Consultation response from KC PROW (footpaths)

2024/93605 Main Avenue

Erection of 57 dwellings with access from new through road connection Main Avenue and Windsor Road and associated works

Date Responded : 10/3/25

Figure 3.2: Public Rights of Way

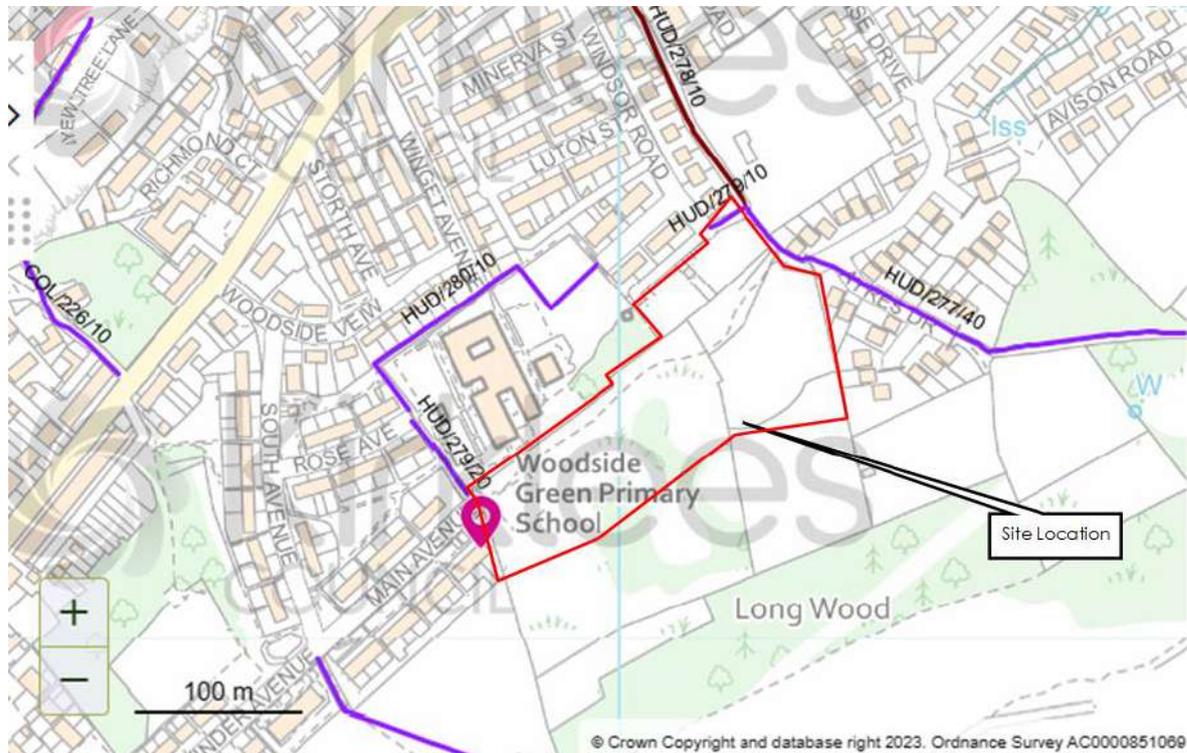
Footpath hud 279/10 run through the site from the end of the byway hud/278.

Prow welcomes the link through the managed land near Warneford Road, but it would be preferable that the alignment does not have the sharp bends in it.

Multiple tread lines through the site are visible and with this area being adjacent to the school prow would not want this section of footpaths off Warneford Road being closed during the development until they are improved. These footpaths give access to Perseverance Street and continued access to the school. This is especially the case, until a connection across the site have been constructed.

The tread lines indicate that pedestrian rights may have been established and prow may receive an application to record rights across the site.

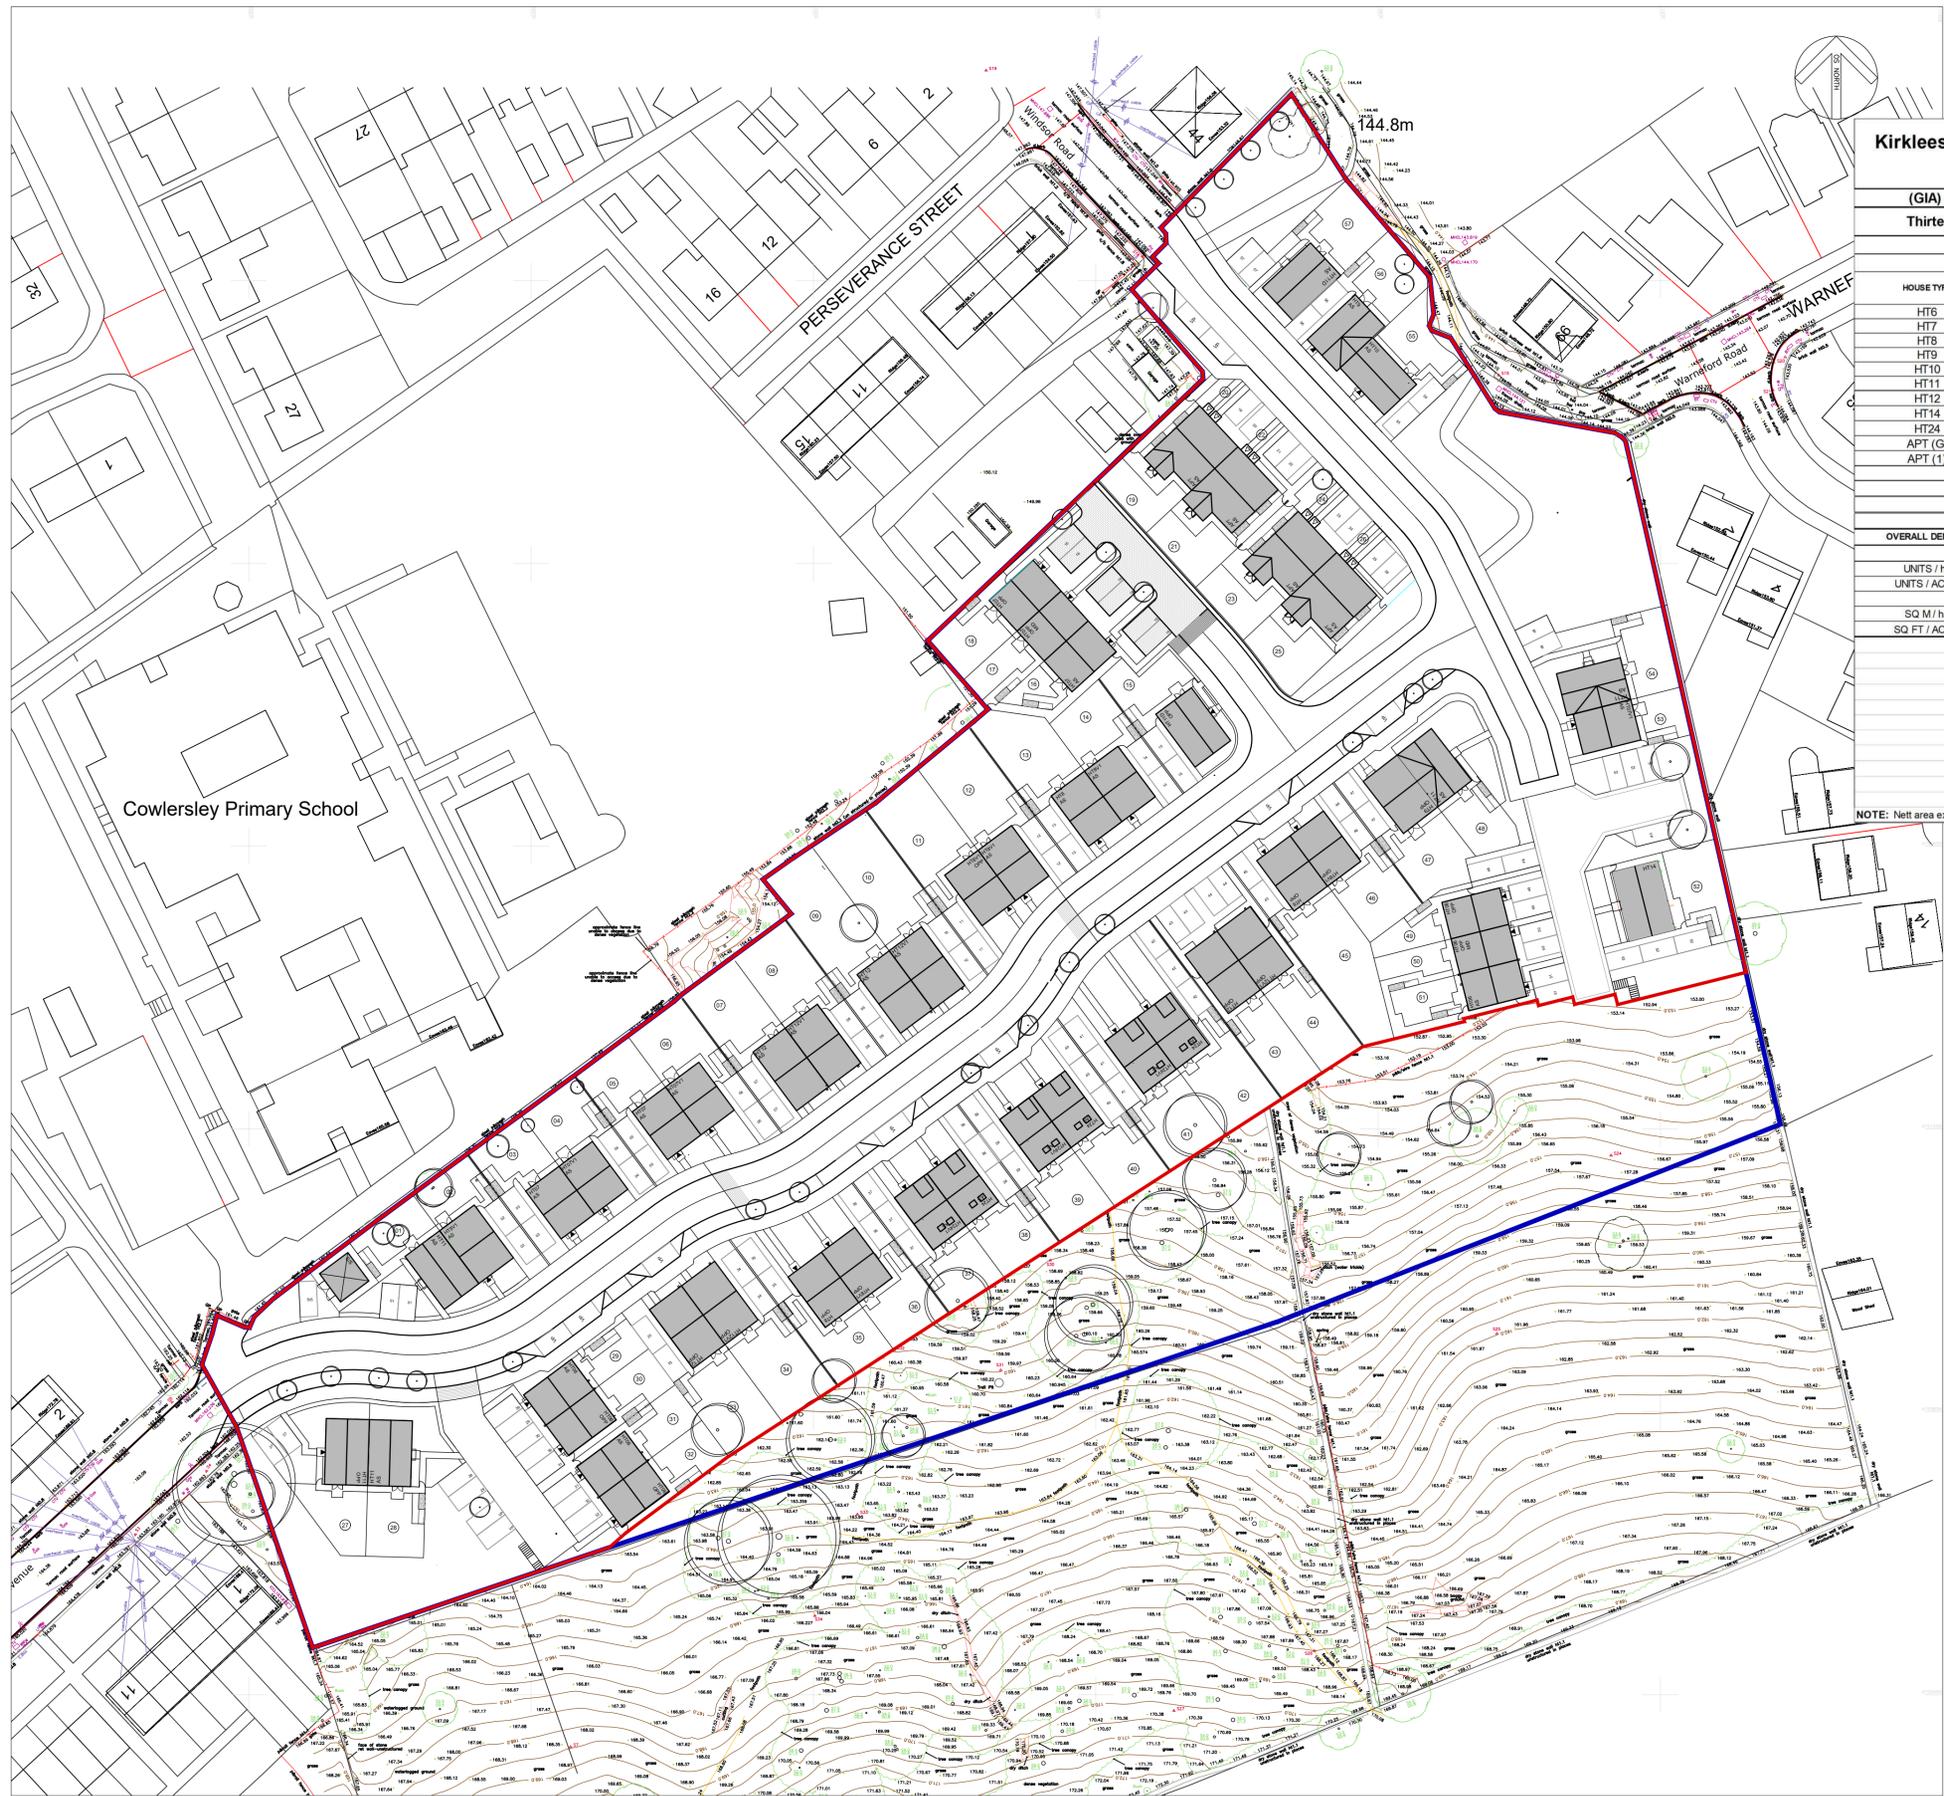
Prow would look for improvements to footpath hud/277/40 from the end of Warneford Road to the end of the byway hud/278. As this section is to be developed, we would want a width of 2 metre due to the gardens of plots 57 and 58 having a 1.8 metre high fence adjacent.

Prow would also look for a 2m width for hud/279/10.
